April 14, 2015

Project Name: Century Tire Plaza  
Address: 195 Kennebec Street, Portland, ME  
Project ID: 2015-027  
CBL: 34-C-9  
Applicant: Northland Enterprises, LLC  
Planner: Nell Donaldson

On April 14, 2015, the Planning Authority approved with conditions a Level II site plan for the redevelopment of the Century Tire site at 195 Kennebec Street. The decision is based upon the application as submitted by Northland Enterprises, LLC and prepared by FST, Inc., with plan revisions dated April 1, 2015. The proposal was reviewed for conformance with the standards of the City of Portland's site plan ordinance, Article V of the land use code. It should be noted that the plans for the project's Marginal Way and Kennebec Street frontages were found to meet the guidelines of the Marginal Way Master Plan and the Somerset Street Extension Feasibility Study respectively, and that the provision of the sidewalk along the property's eastern boundary was found to meet the city's B-7 and site plan standards related to street connectivity and safe access for all site users. The Level II site plan is approved with the following waivers and conditions:

FST 100 YEARS	FAY, SPOFFORD & THORNDIKE ENGINEERS - PLANNERS - SCIENTISTS 778 MAIN ST., SUITE 8, SOUTH PORTLAND, ME 04106
DRAWN: KGS	DATE: 6/9/15
DESIGNED: ADJ	SCALE: AS NOTED ON PLANS
CHECKED: ADJ	JOB NO: 15-018
FILE NAME: SP-1	SHEET: C-7.0

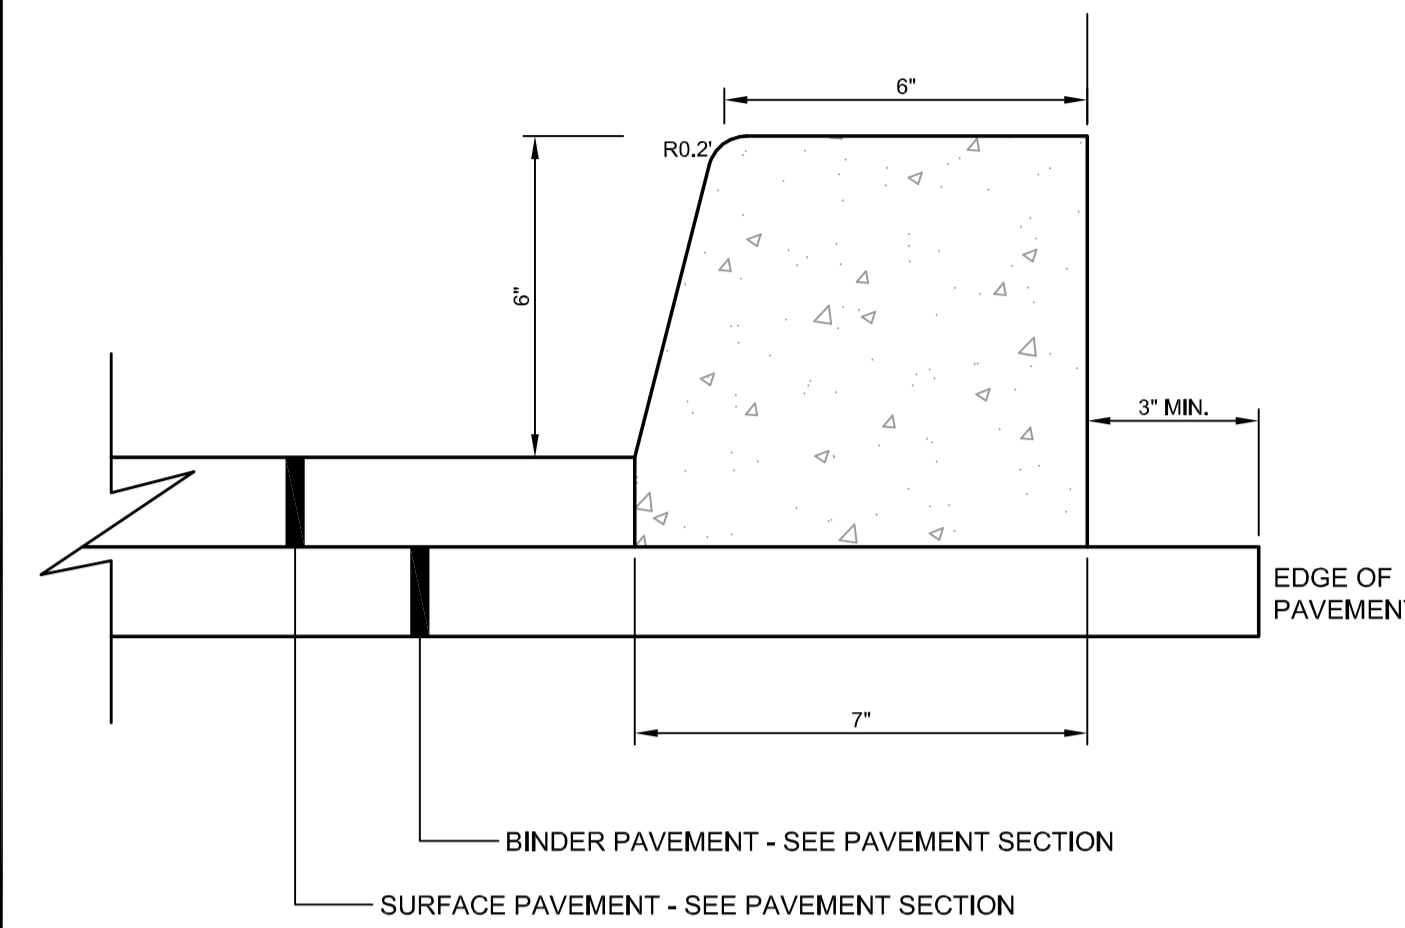
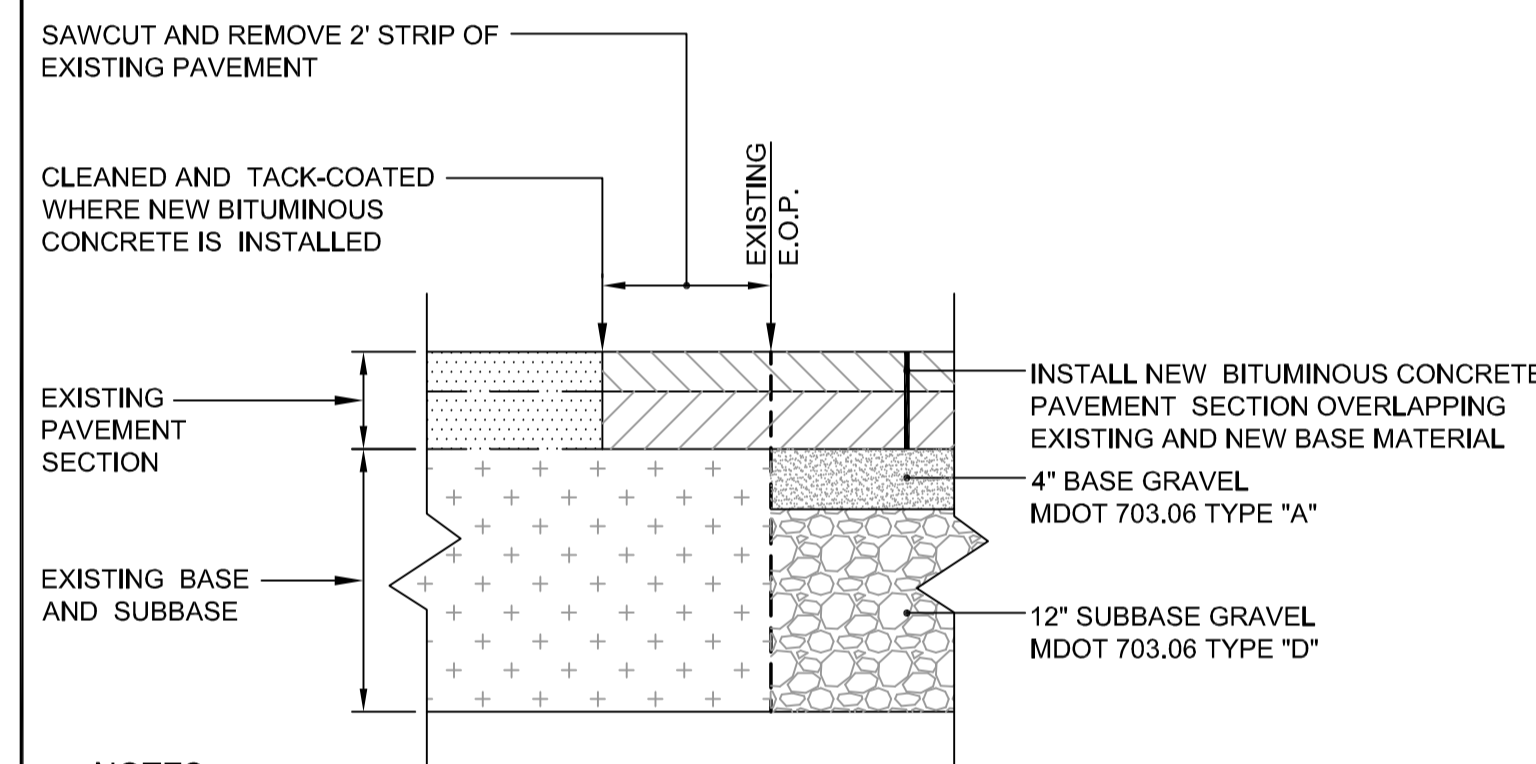
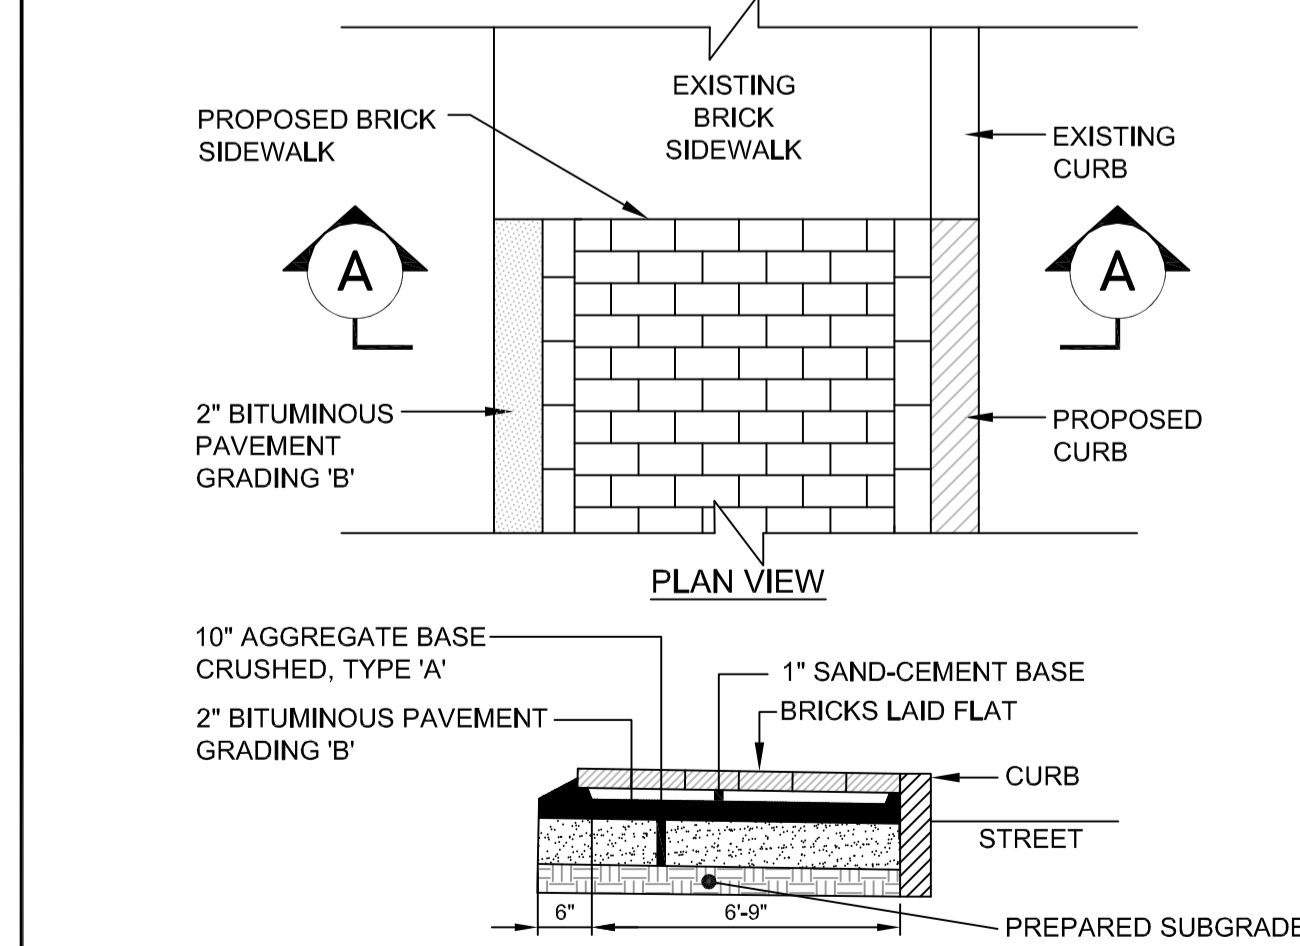
Detail C on plan sheet C-7.0, detail D on sheet C-7.2, and detail E on sheet C-7.2 all should be corrected to show the City standard for depth of base gravel for a brick sidewalk on bituminous base. The depth of gravel should be 10 inches, not 4 inches as indicated in the above referenced details.

6. The applicant shall revise details to depict the city's standards for curb reveal and depth of base gravel for a brick sidewalk on bituminous base for review and approval by the Department of Public Services;
